14 April 2026

SSD 96505456
DA479/25
JD6 (P&E)

**STATE SIGNIFICANT DEVELOPMENT APPLICATION 96505456
19-23 ROSALIND STREET CAMMERAY
SENIORS HOUSING
PERIFA ROSALIND DEVELOPMENT PTY LTD**

SECTIONS

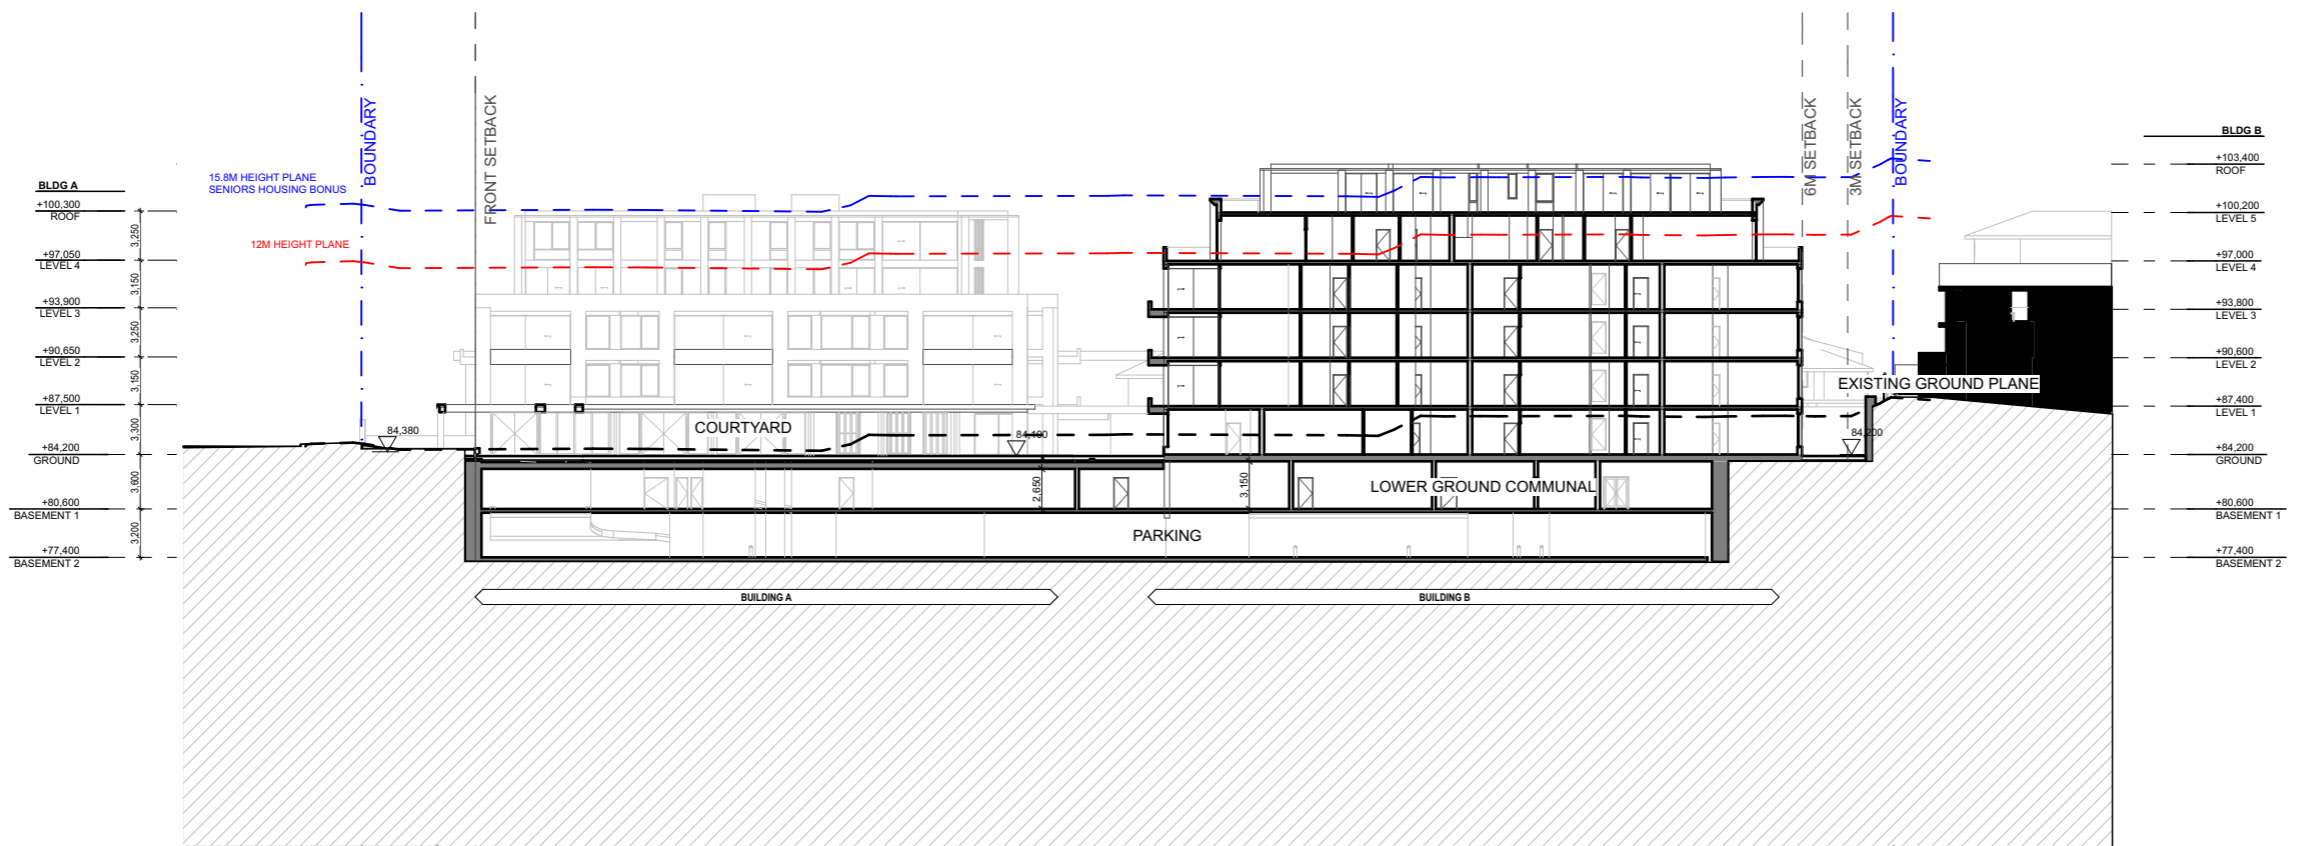
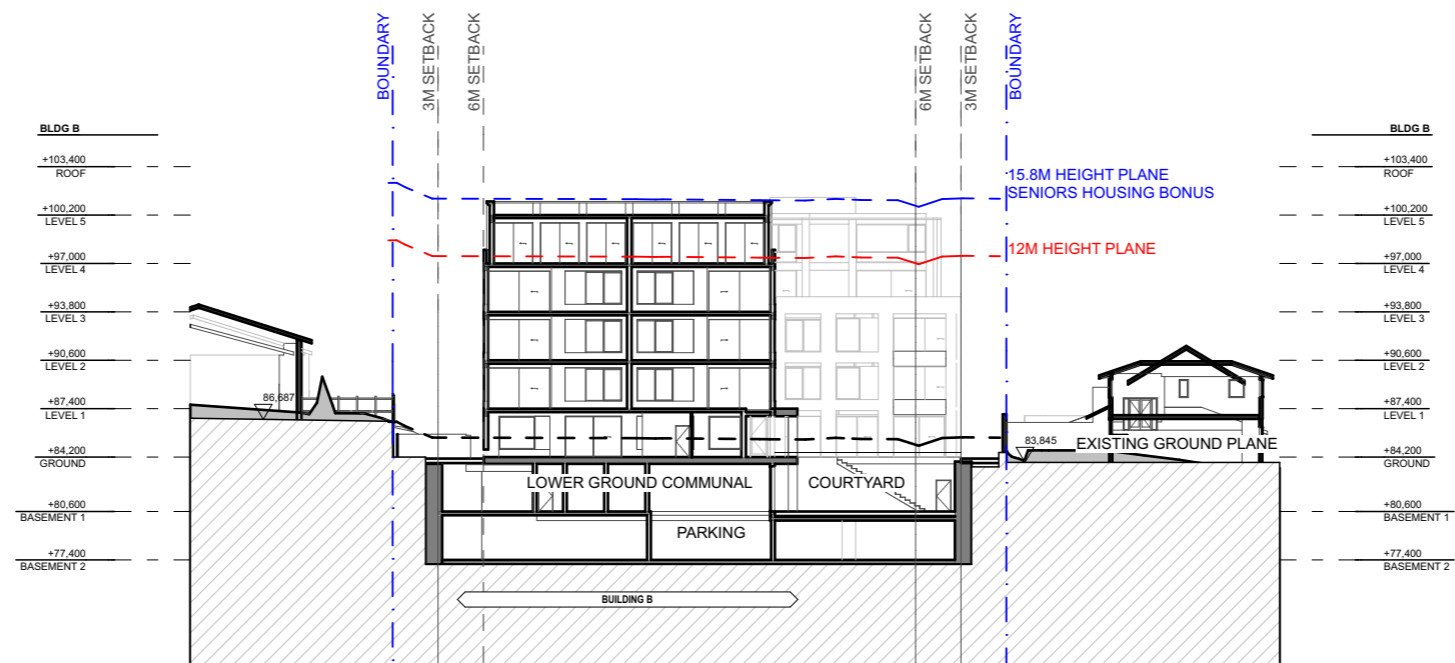
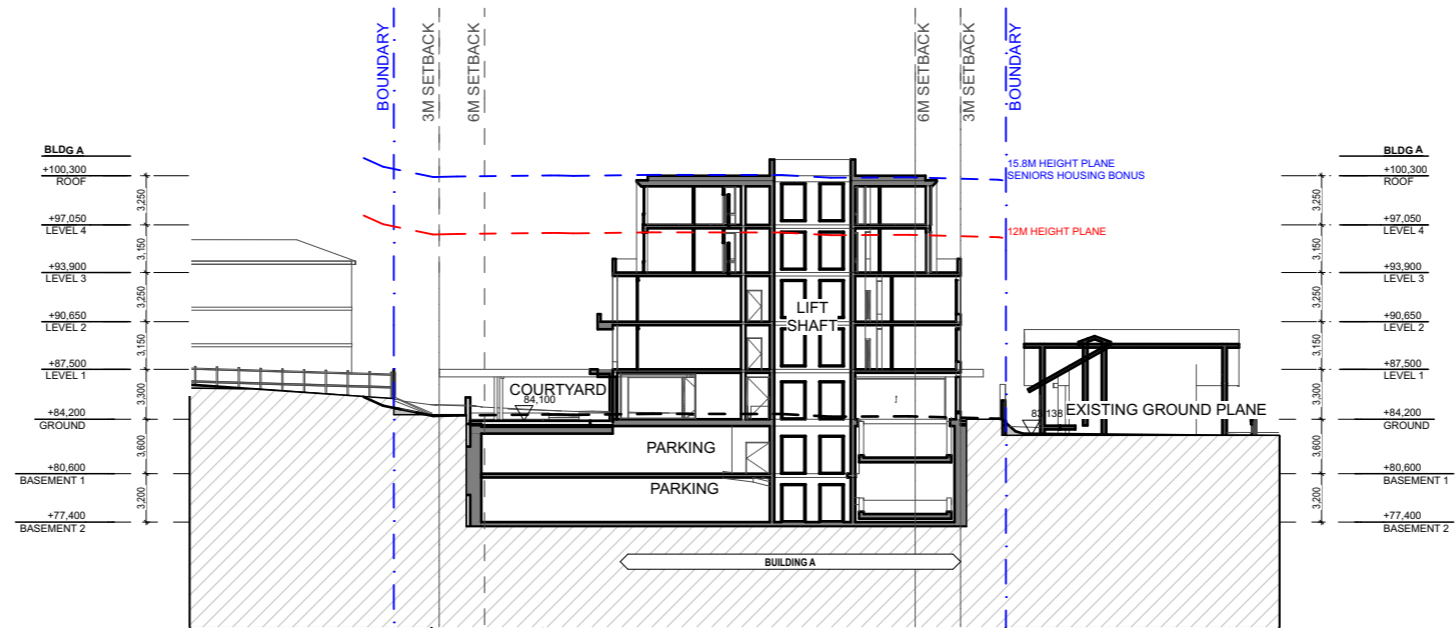
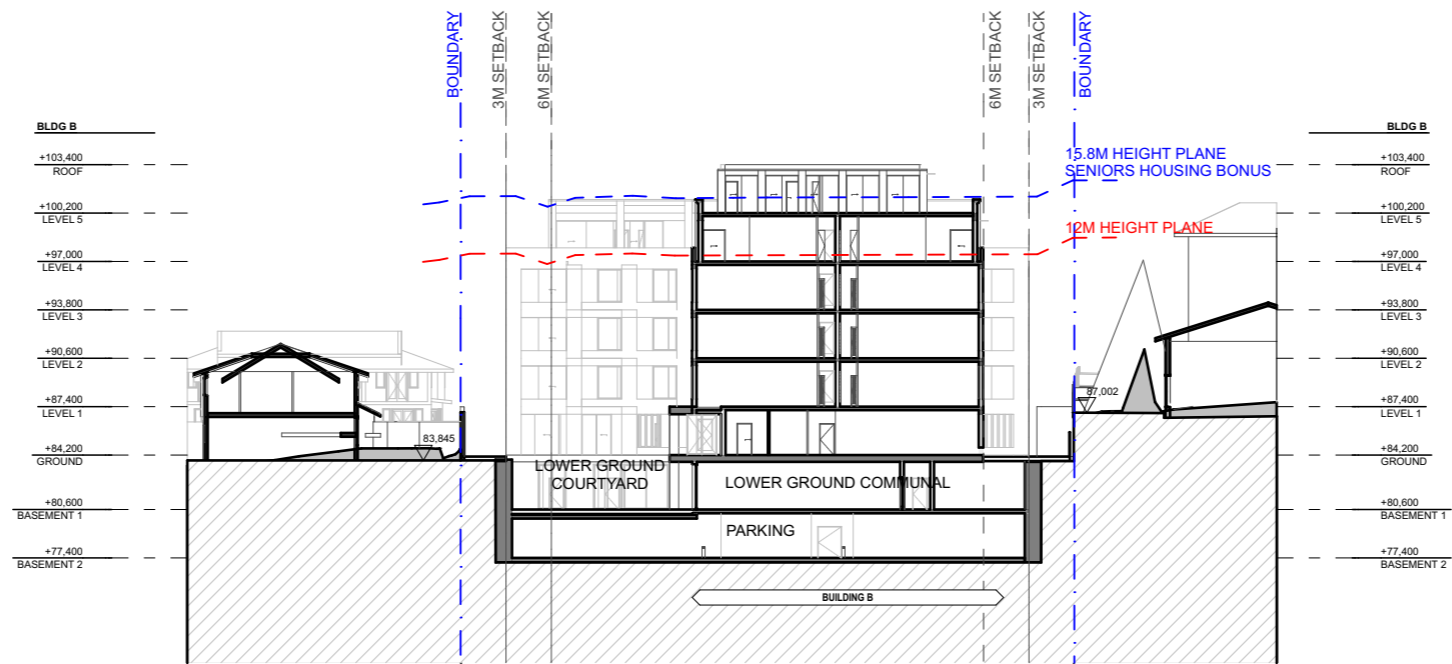
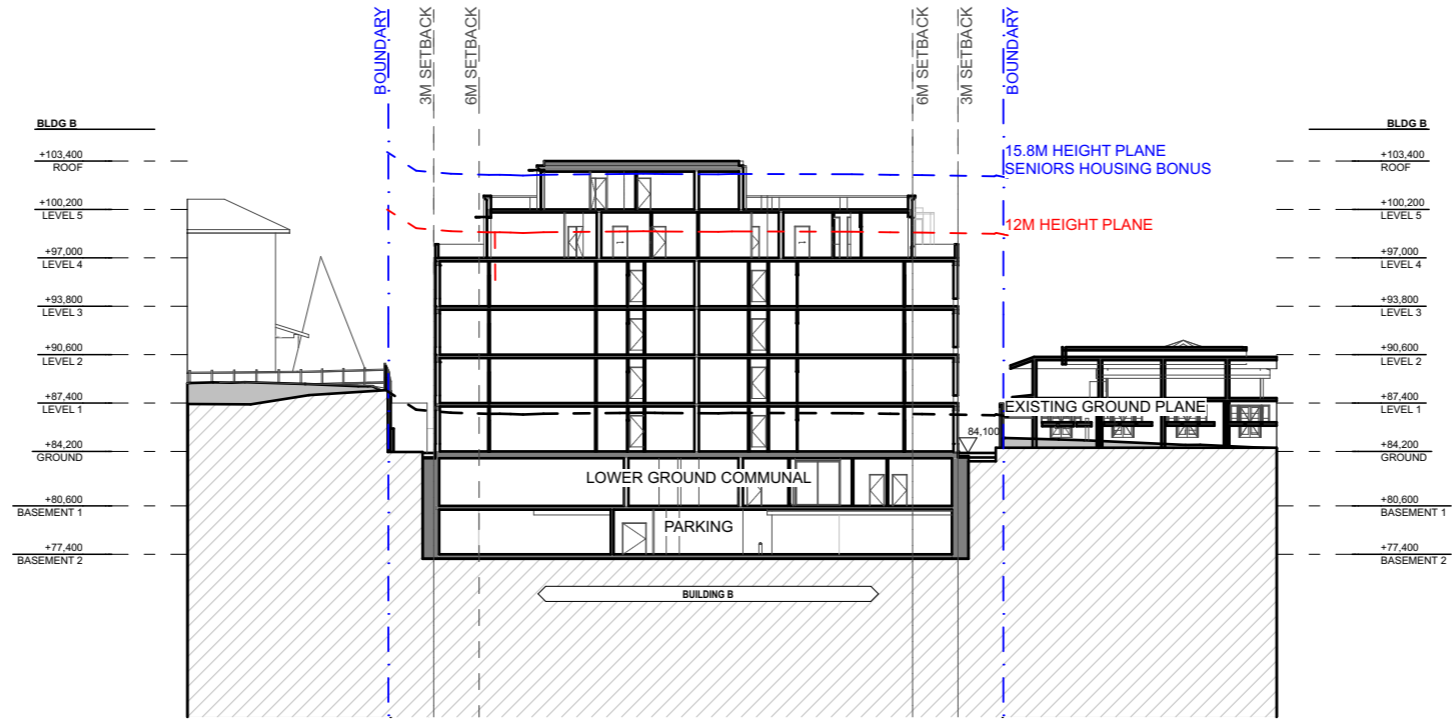
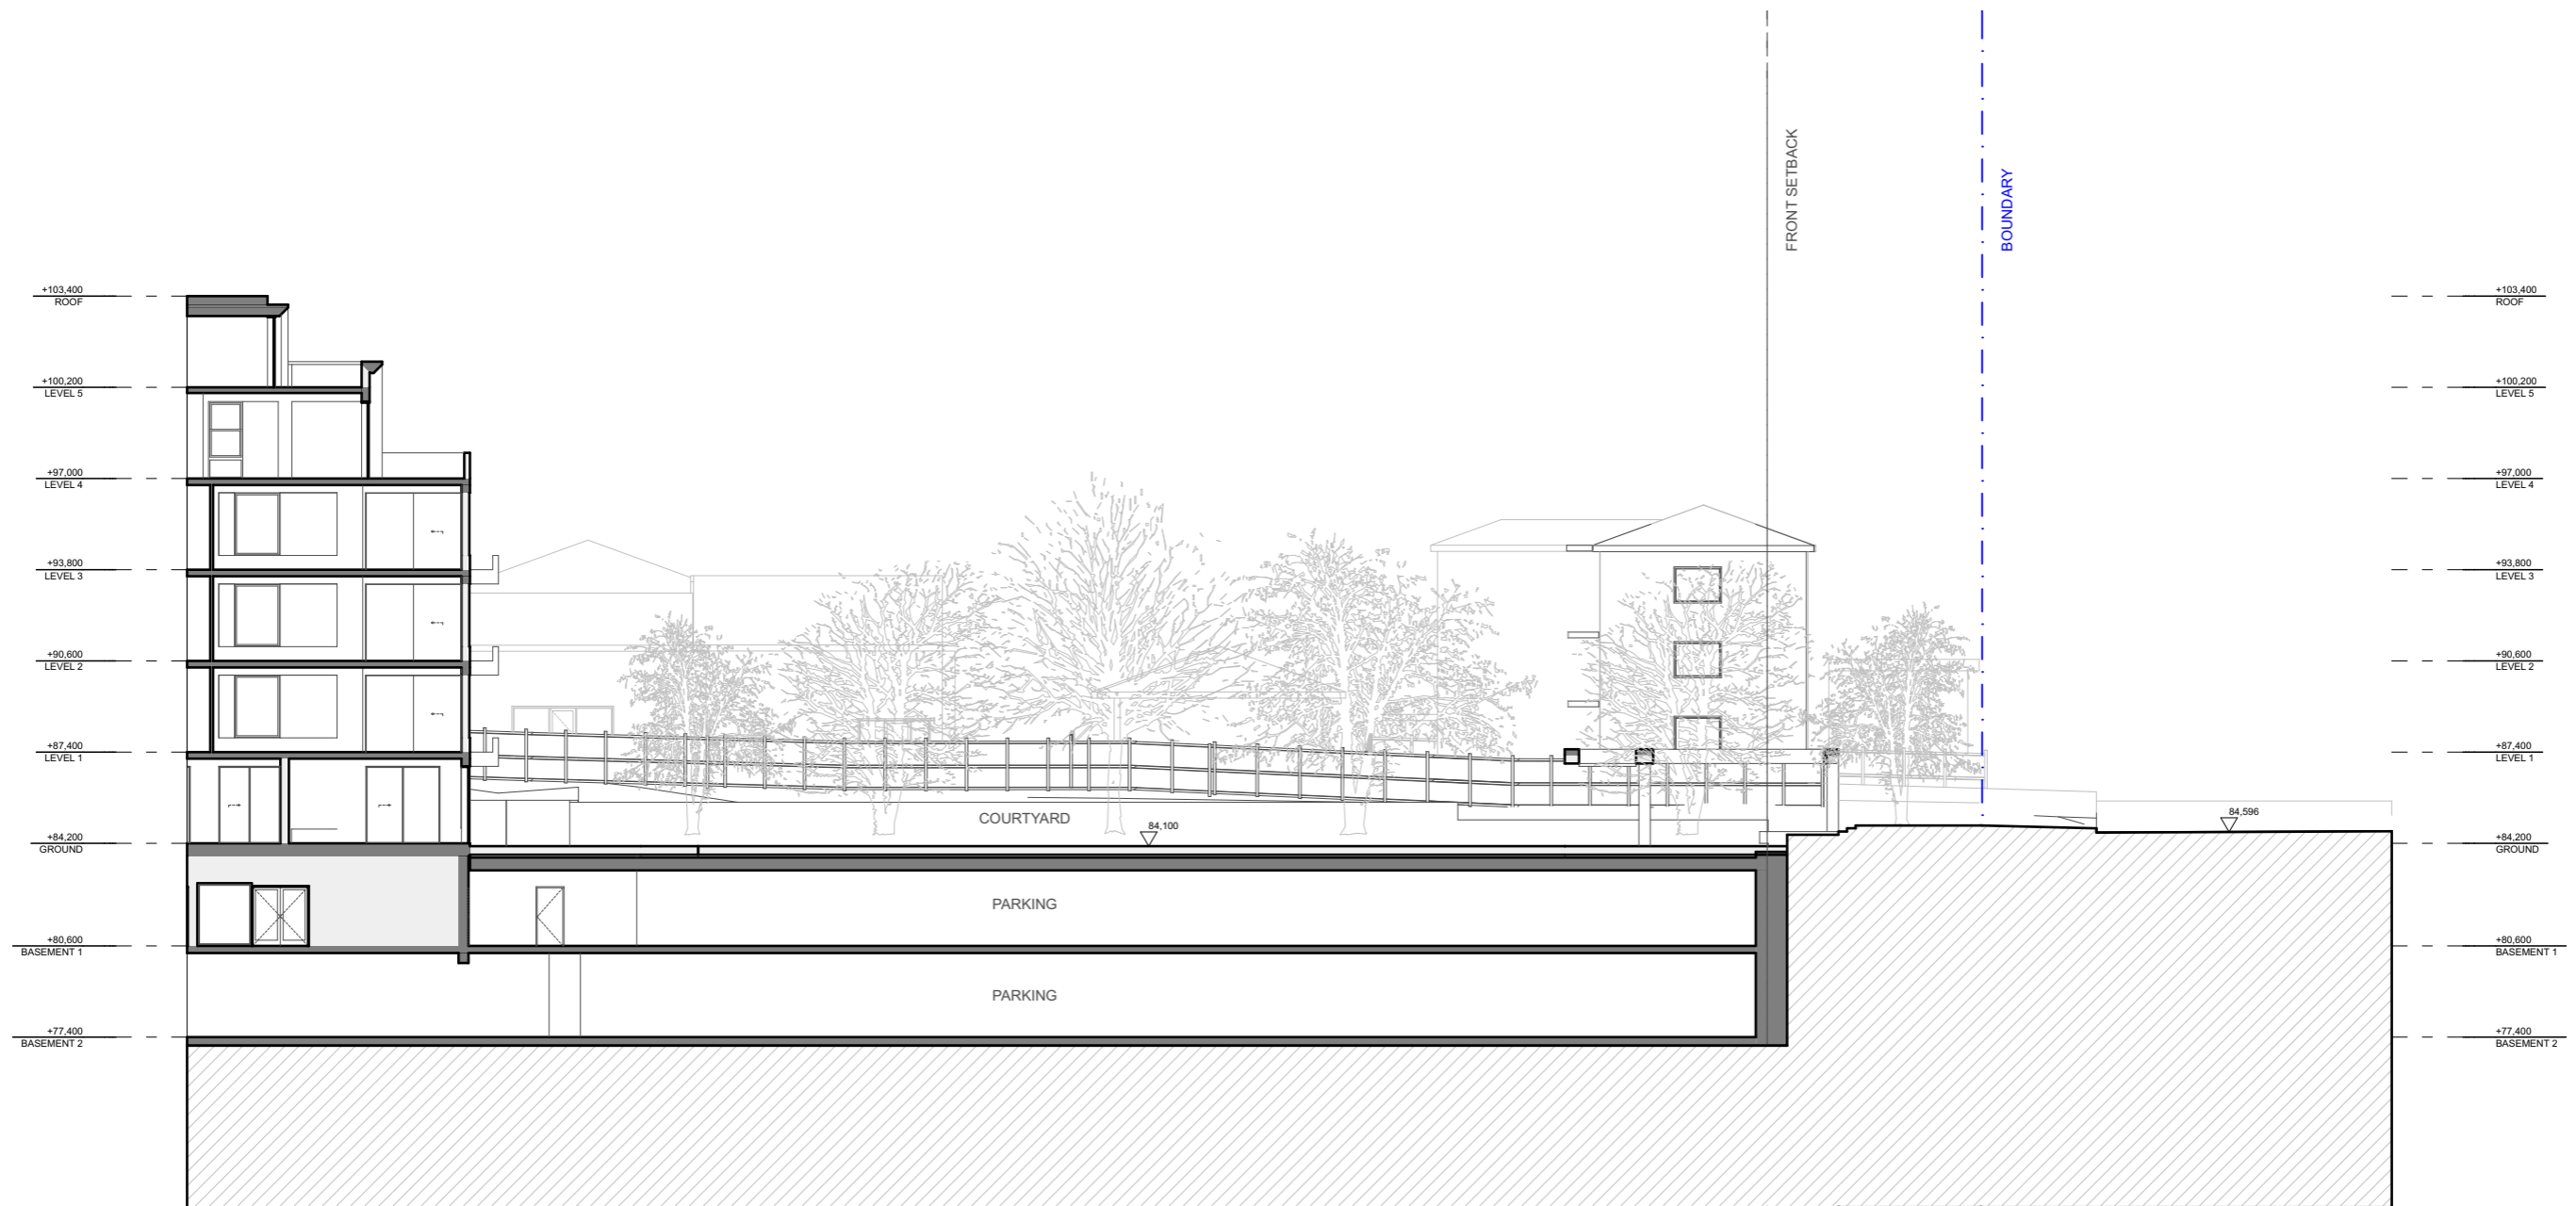
All proposed communal open space is planned above structure, which does not qualify as deep soil and would not support planting and sustained health of shade-providing canopy trees. Section A in the architectural drawings indicates the top of the slab has a finished level of 84.2m. The architectural and landscape plans show the finished level – 84.1m. There appears to be no room available for any soil to enable plants (100mm), including the Flame Tree proposed at the main communal open space's southern end.

3. *The design be reviewed to increase the amount of landscape area and deep soil zones to comply with the SEPP's minima and enable judicious planting of shade-providing canopy trees and complementary vegetation in areas of communal open space and other spaces in the development.*
